Application for a Non-Material Amendment Following a Grant of Planning Permission

Number	47
Suffix	
Property Name	Mallondene
Address Line 1	Mallon Dene
Address Line 2	
Address Line 3	West Sussex
Town/city	Rustington
Postcode	BN16 2JP

Erection of single storey rear extension following demolition of existing rear extension

R/258/21/HH

P06 Proposed Floor Plans

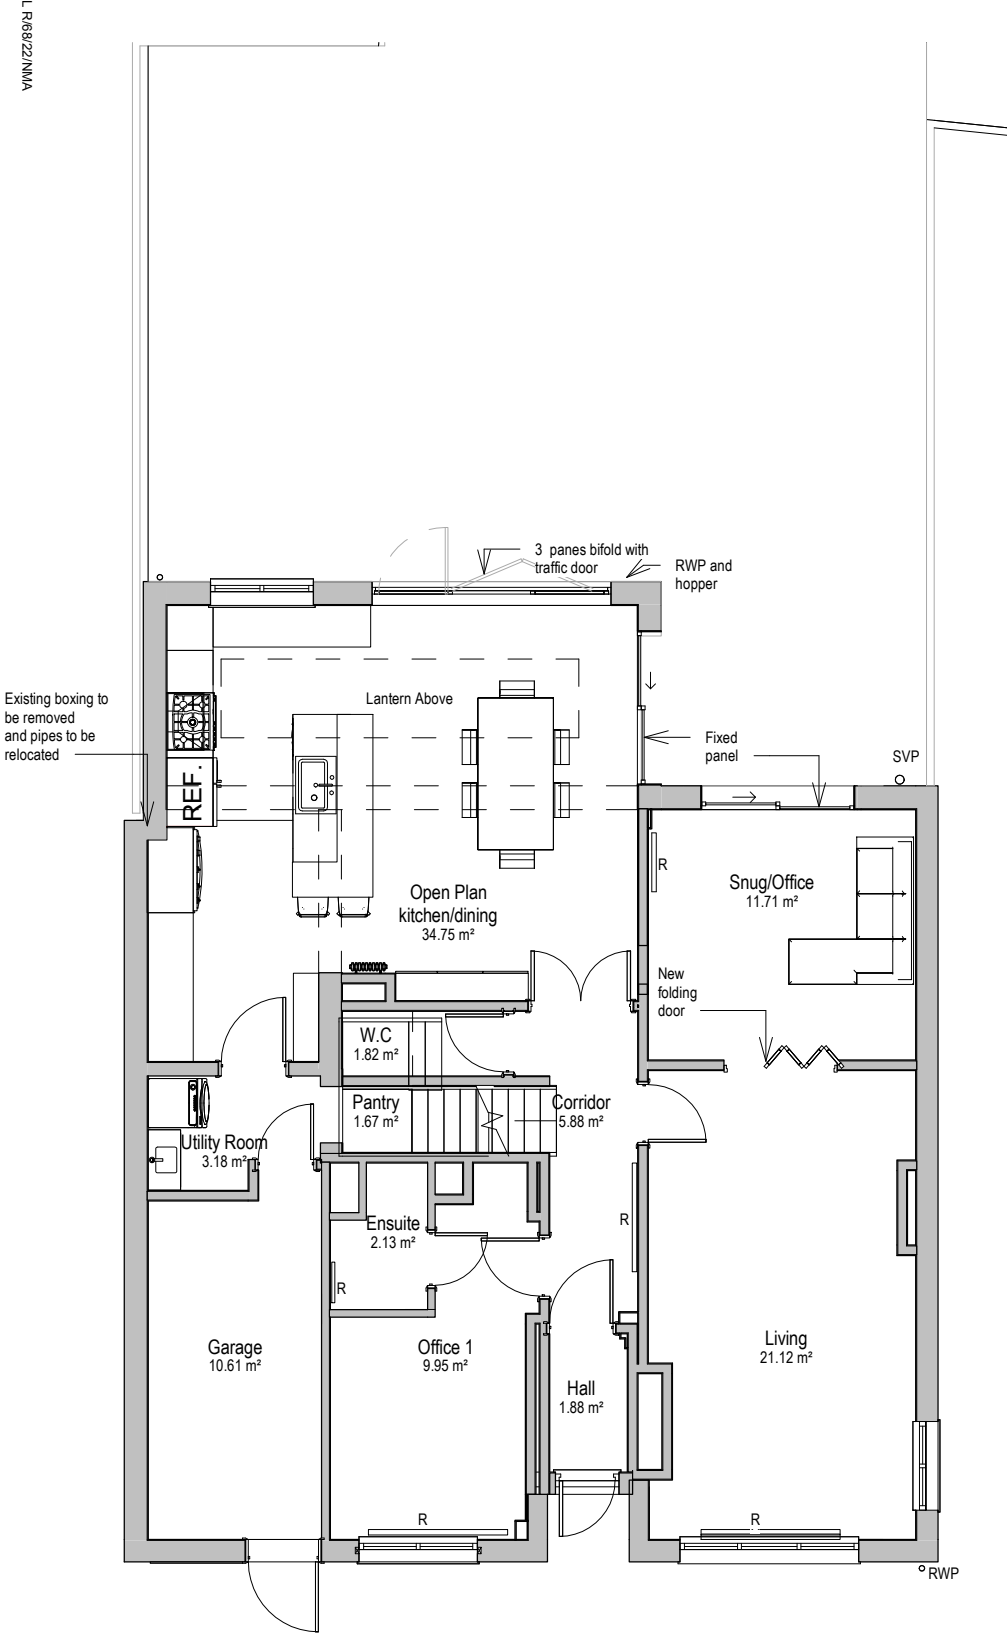
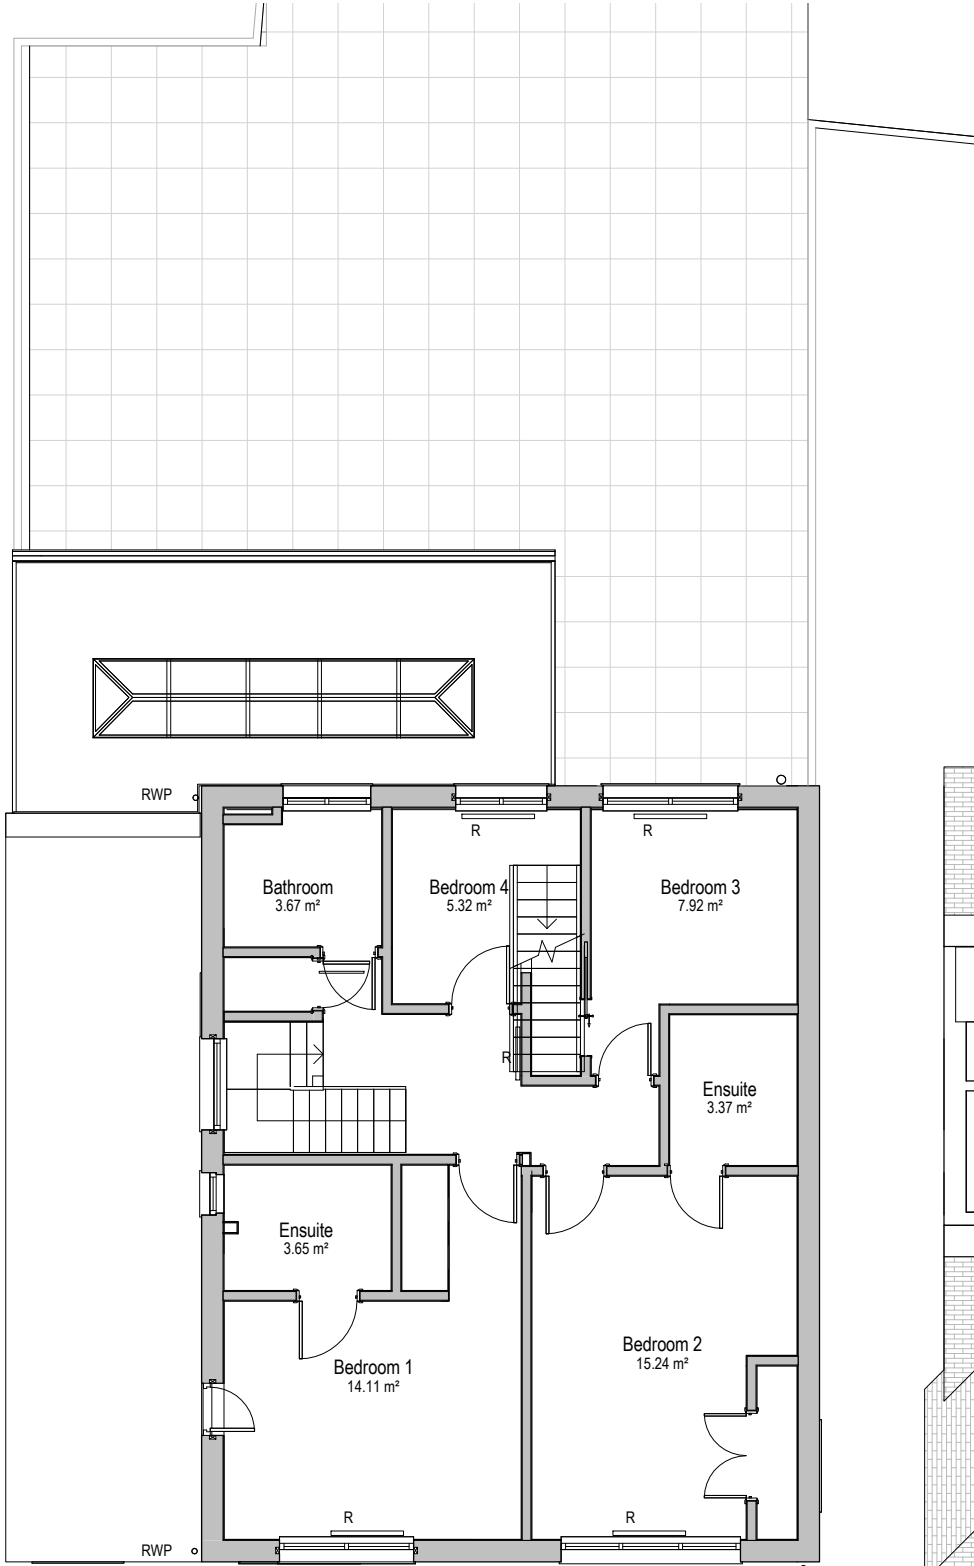
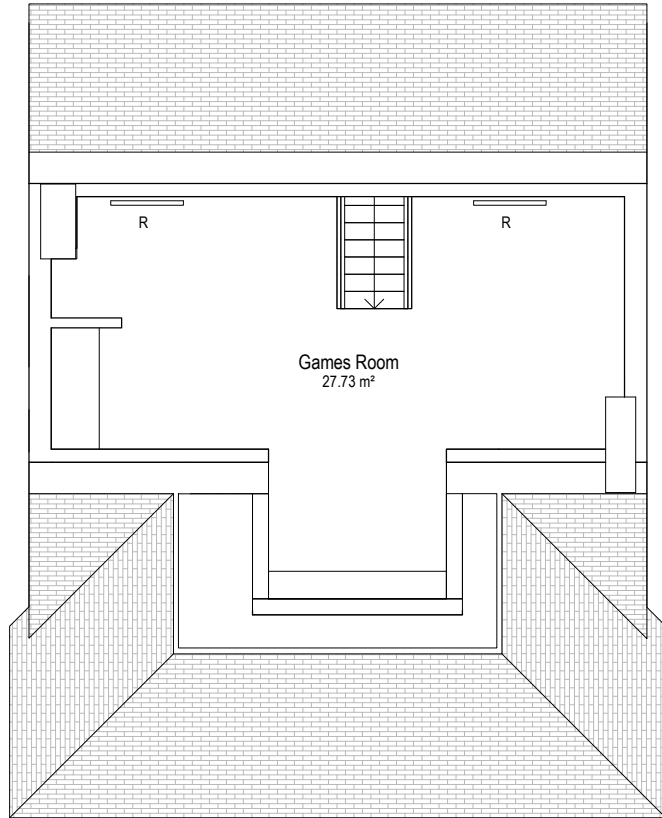
Addition of a window to the rear of the extension.

To improve ventilation to the proposed kitchen space.

P06 - Proposed Floor Plans P2
P08 - Proposed Elevations P3
